Planning Application: Seeking advice on an **OUTLINE** planning application for this site for 175 residential units

Reference: **A/99/17/OUT (2)** *Current Comments in blue typeface*

Location: Land south of Water Lane, Angmering

Tree Protection Plan

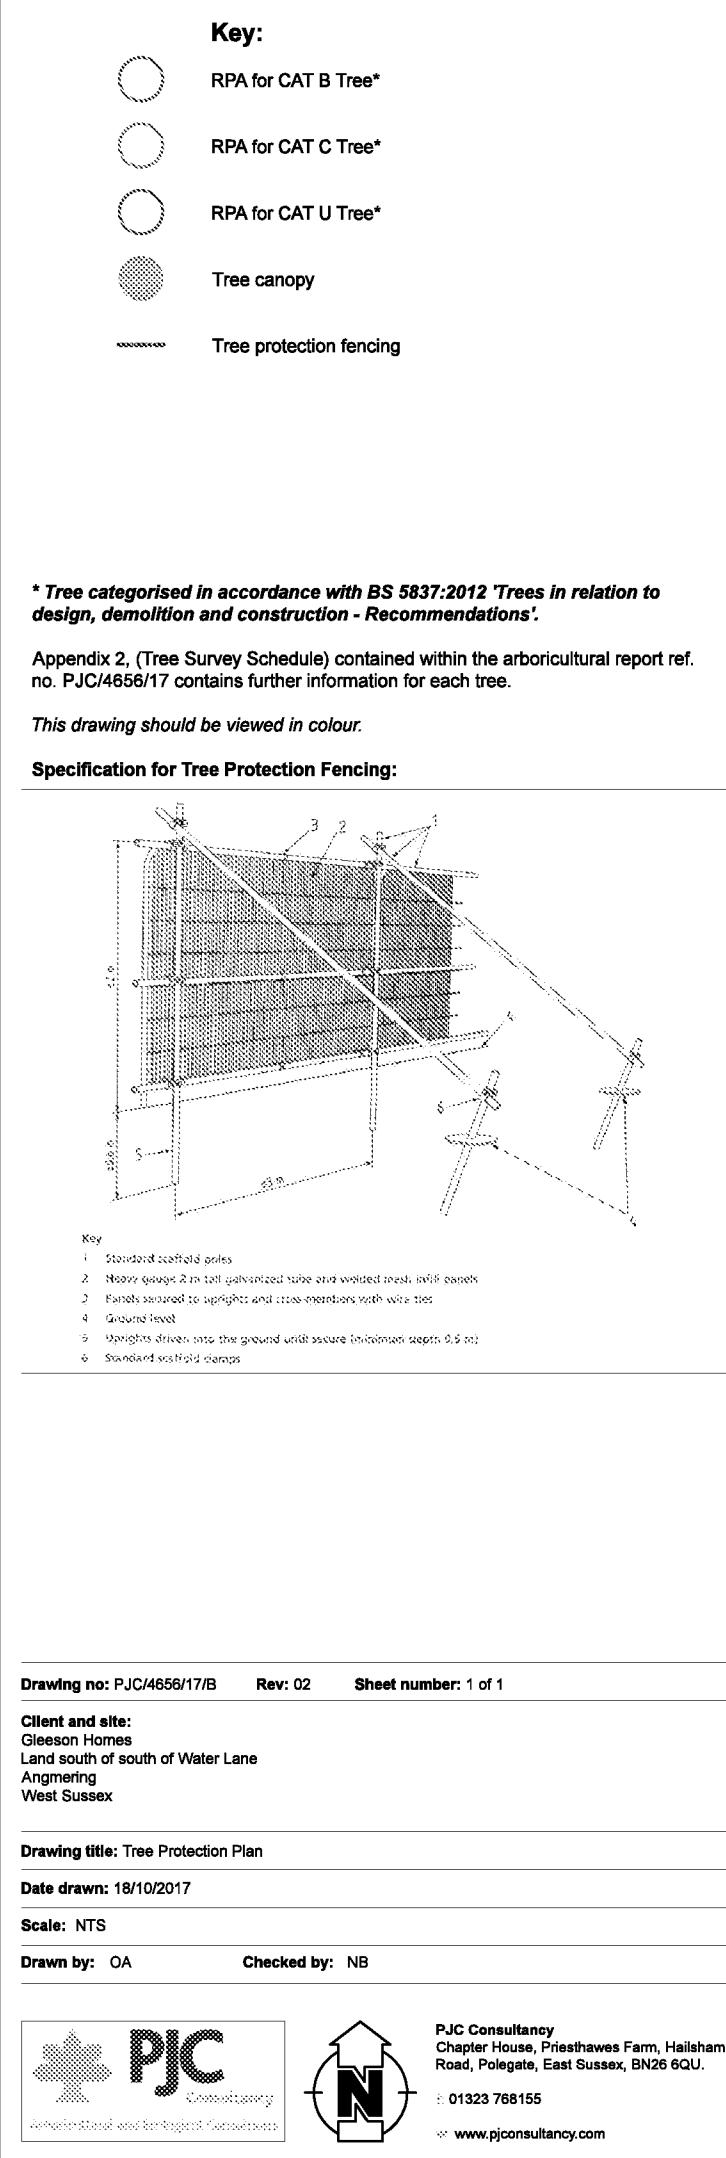
- *The current Tree Protection Plan has now been drawn onto a version of the Masterplan but unfortunately the one they have chosen to use is not up to date and the revisions to the layout are not shown on it so I cannot accept this for assessment. I also question the validity of preparing a very detailed Tree Protection Plan for an outline application – inappropriate in my view as it should only come in to accompany a detailed layout at a later date.*

Drawing title: Tree Constraints Plan

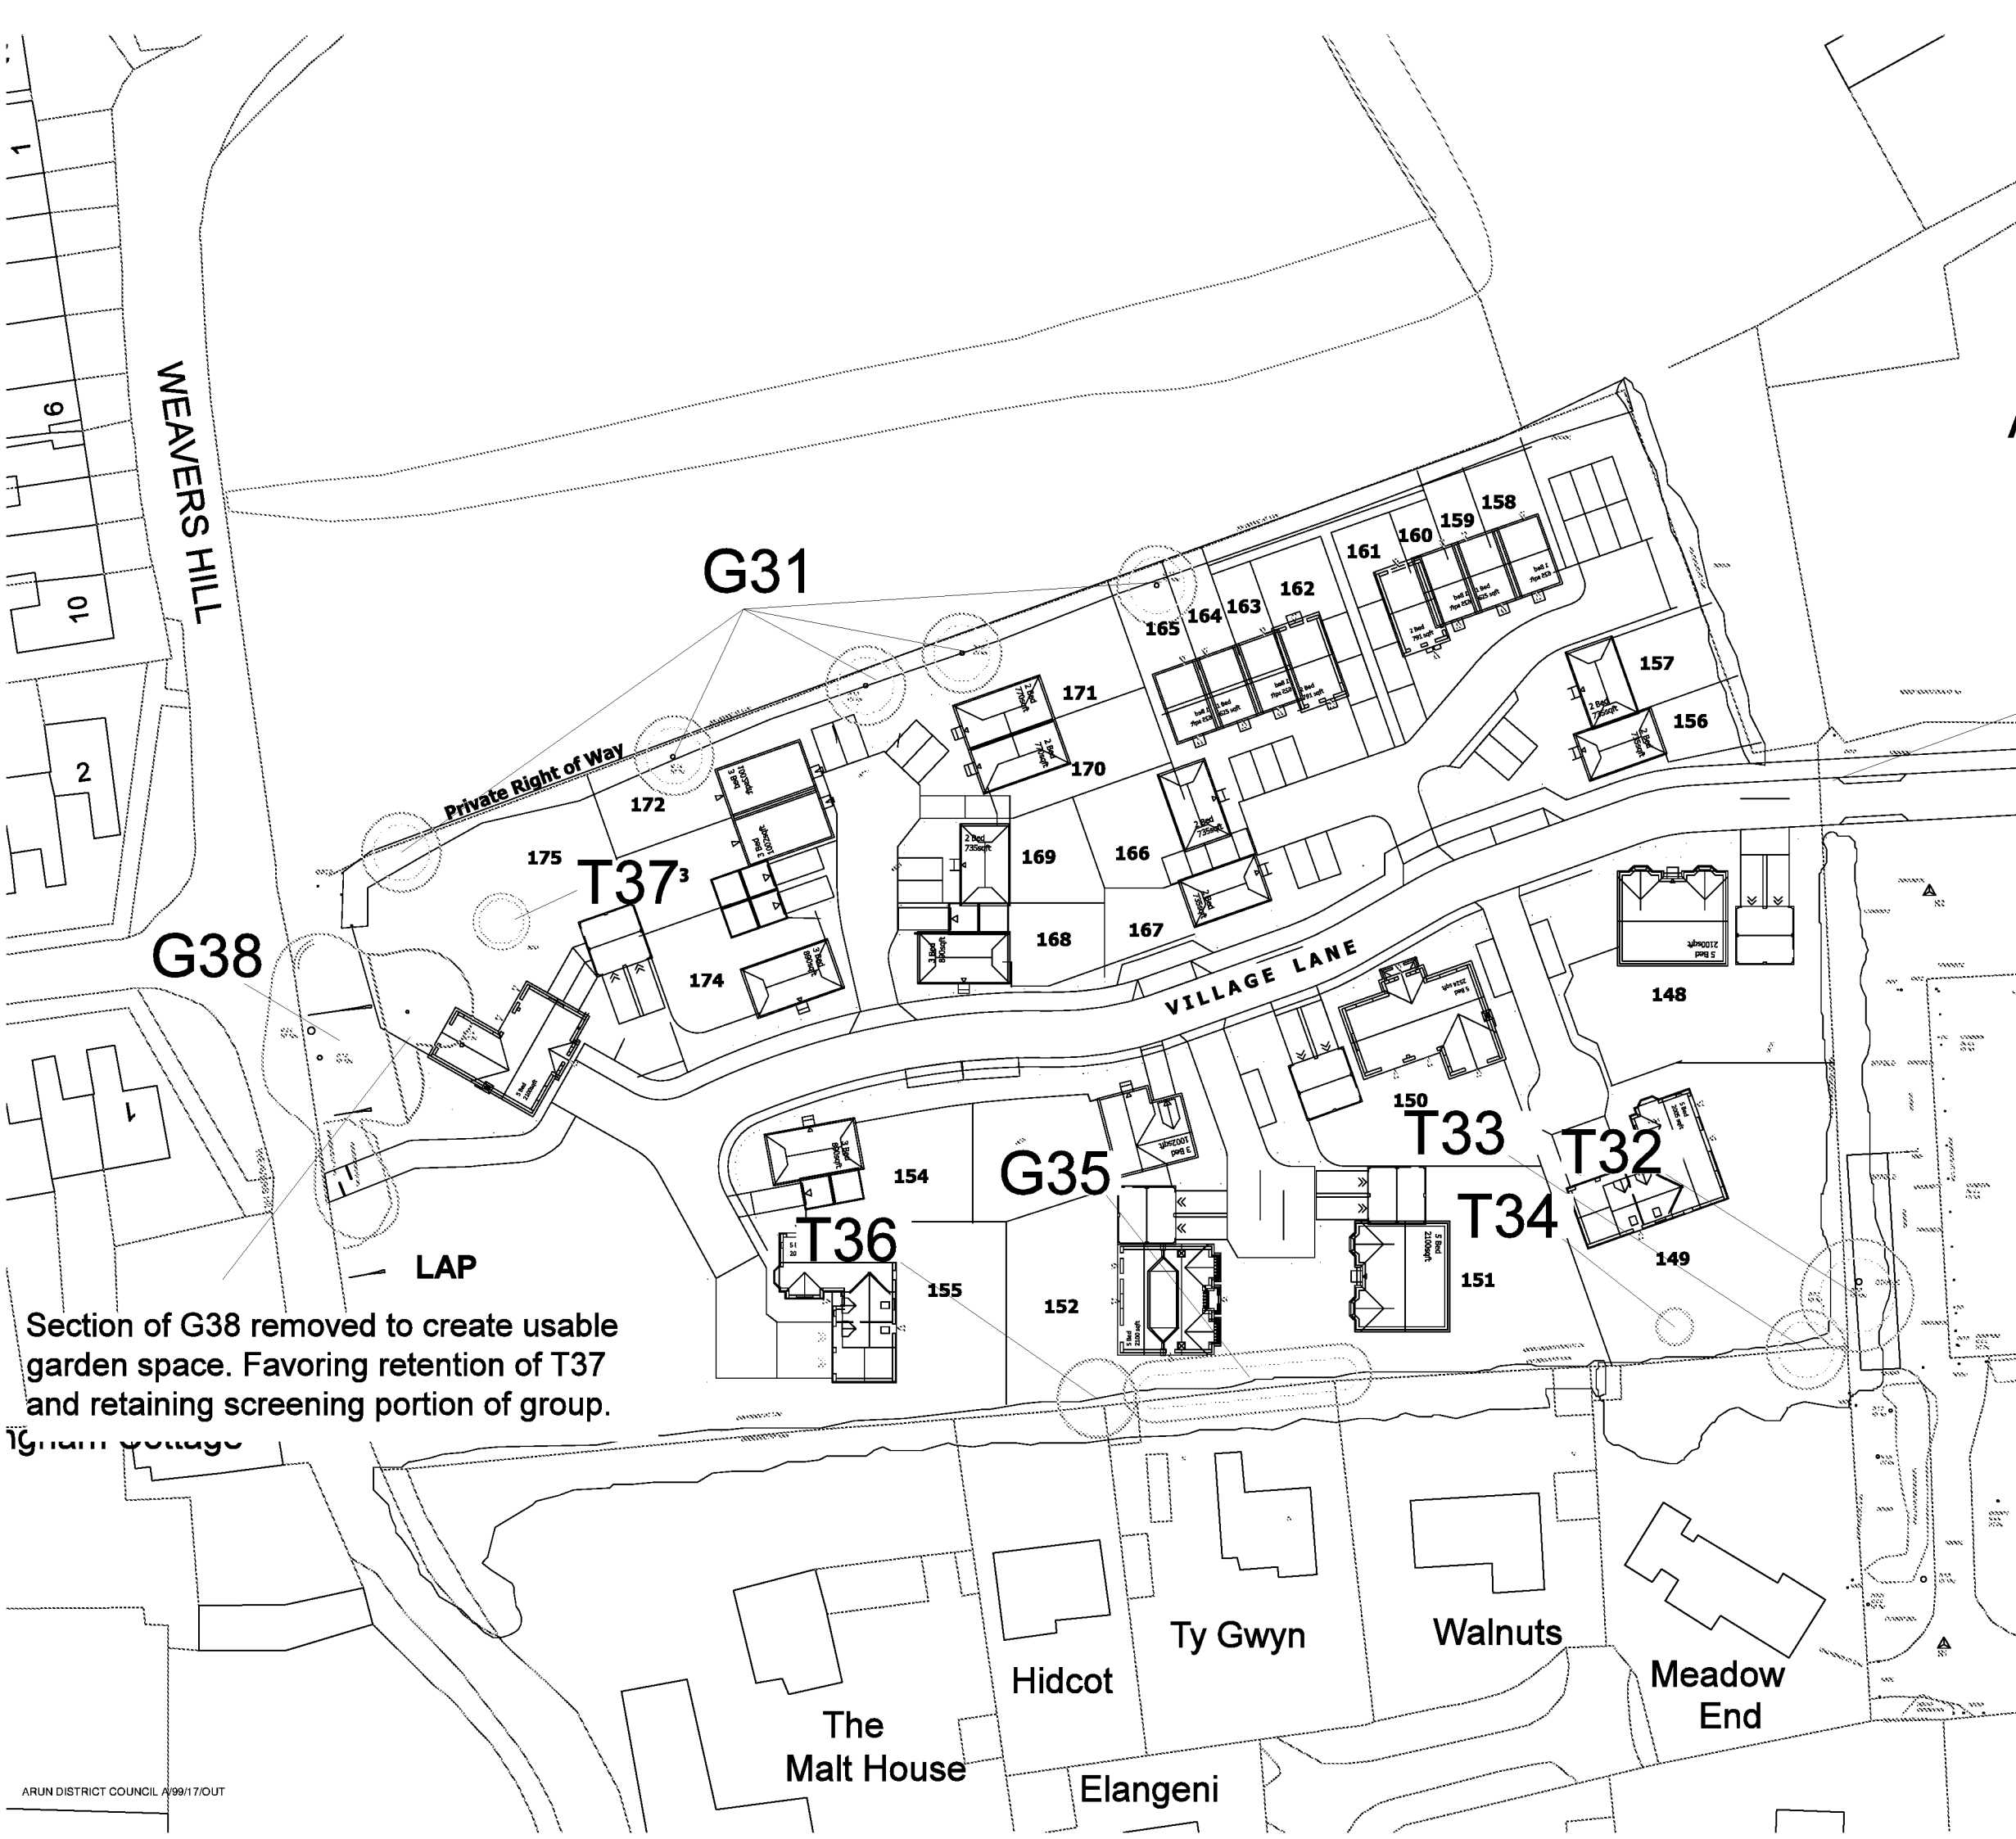
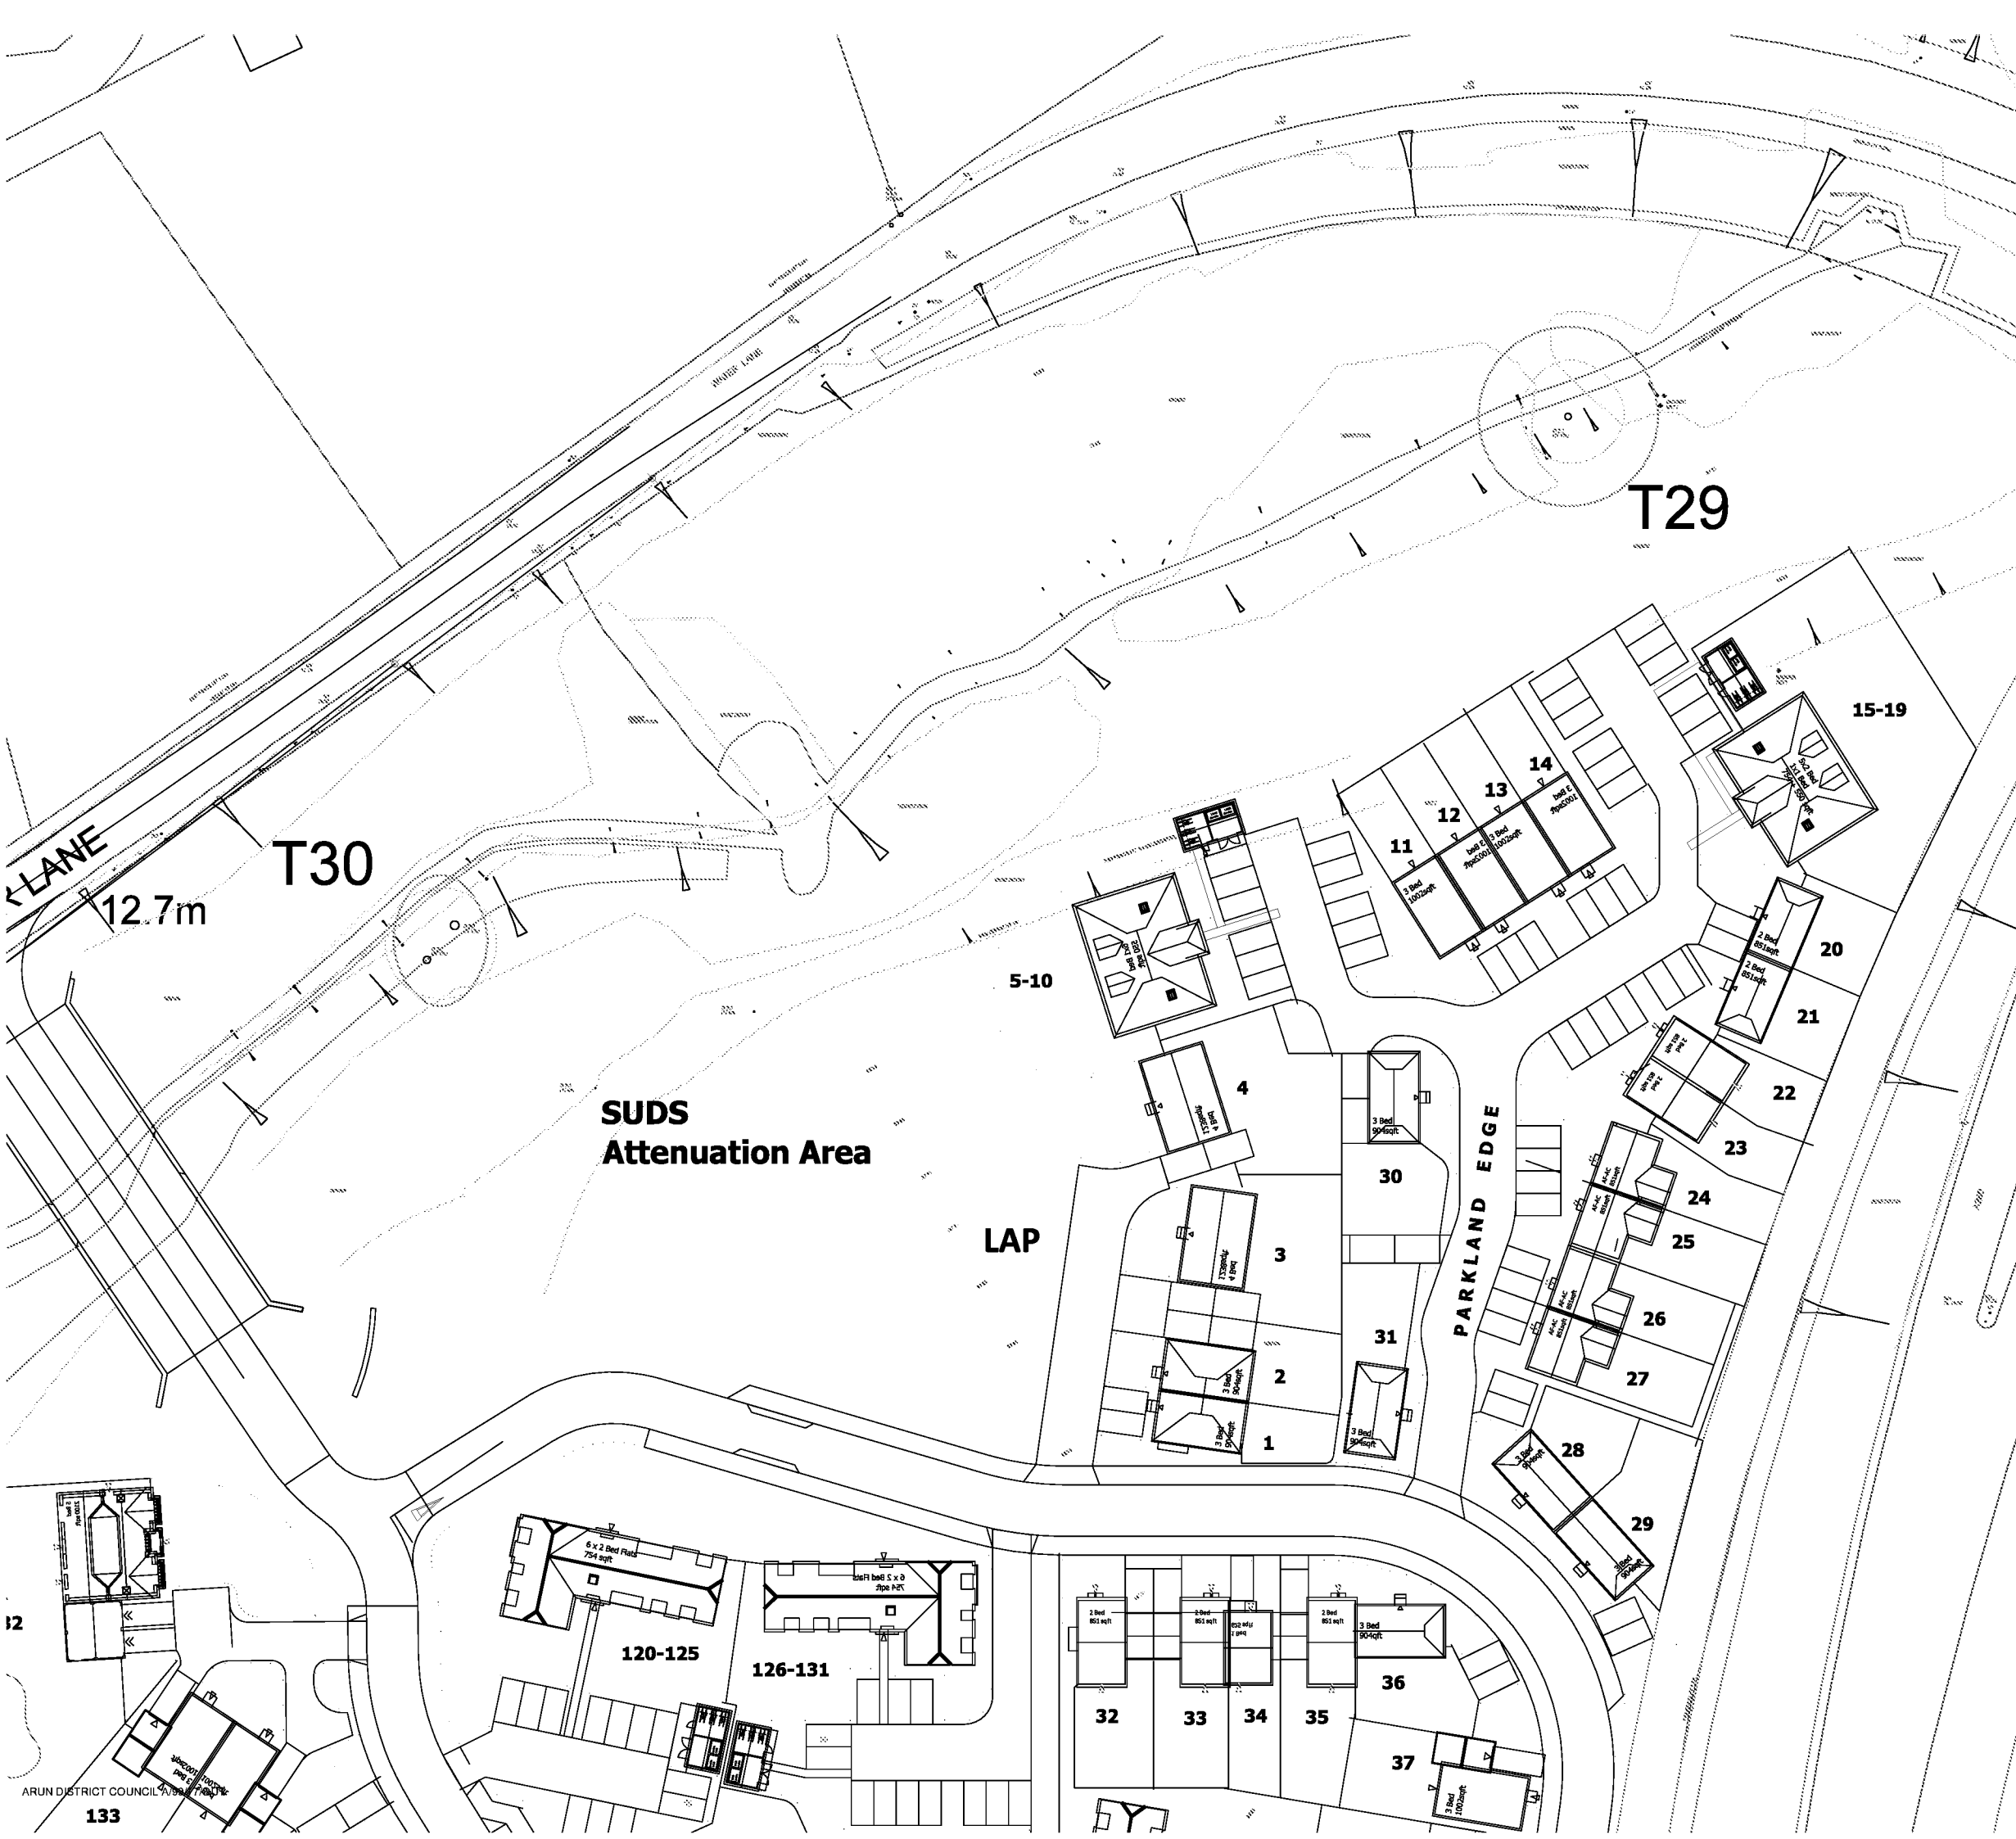
- In my review of the Illustrative Masterplan 1911/PO3 Rev E I note that in Plot 175 it shows a large garden area and no access out onto Weavers Hill and yet the PJC AIA says that it will be necessary to remove the good young specimen Oak T37 – I cannot see the justification for this!

- *We are now on Illustrative Masterplan 1911/PO3 Rev E and Plot 175 now has a huge dwelling on it which directly threatens the future of T37 Oak (which I have recommended for a TPO) – I am not happy with this juxtaposition.*

- Plot 171 & 172 place pressure on two young Lime trees in Grp 31 and whilst I note that they suggest the removal of one of these trees the other one is proposed for retention and this would be under immediate pressure to be ‘pruned or felled’ given that it is a young tree with significant growth potential for the future.

- *Nothing has changed with the new layout and these two trees (recommended for TPO) remain under pressure and I am not happy with this juxtaposition.*

- Further to this the access drive and parking bays will overlap the RPA of another retained Lime in this group and yet this is not mentioned in the AMS report?
